June 7, 2019  
File: 161413551

**Reference: Peer Review of Sysco Tannis Facility Stationary Noise Assessment Report -  
2300 Stevenage Drive, Ottawa, Ontario**

Stantec Consulting Ltd. (Stantec) was retained by the City of Ottawa to conduct a peer review of the following documents with respect to stationary noise assessment of Sysco Tannis Facility located 2300 Stevenage Drive in Ottawa, Ontario:

FIGURE 4:
RECEPTOR LOCATIONS

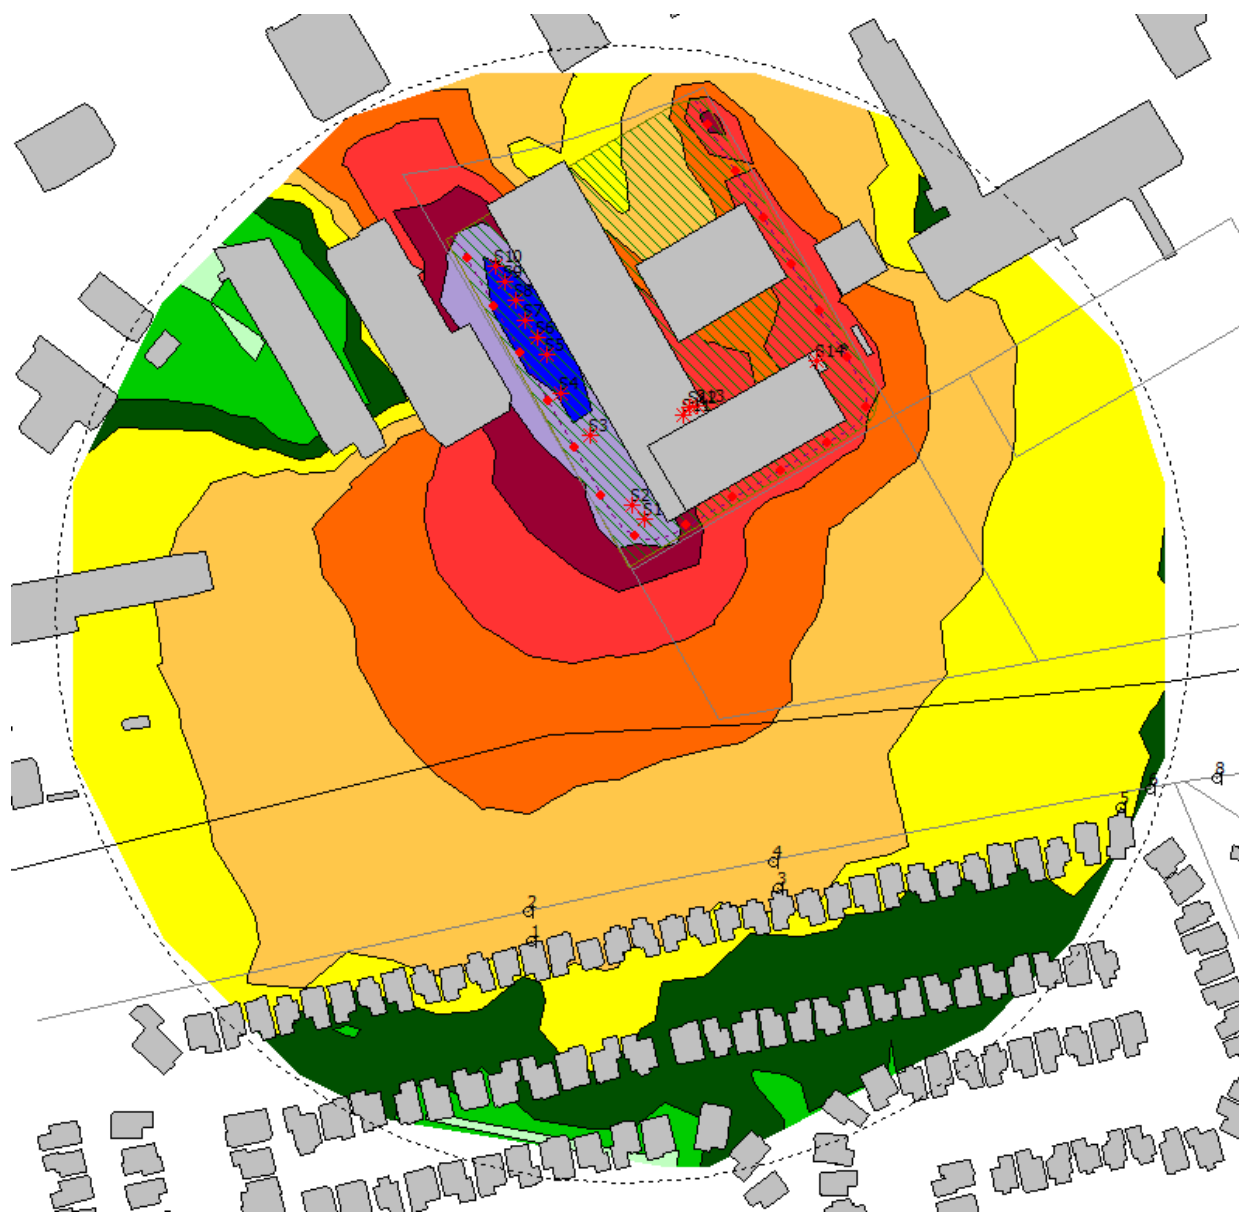
- b) The acoustic report identifies eight (8) Points of Reception (POR) and they are representative receptors considered for the assessment. The receptors identified for the project include both outdoor and plane of window PORs as required.

- i) A calculation check of the facility by Stantec indicates that the GWE noise model under-predicts sound levels at the first row of receptors. This may be due to time weighting used for the reefers and the sound level measurement/calculations mentioned above.
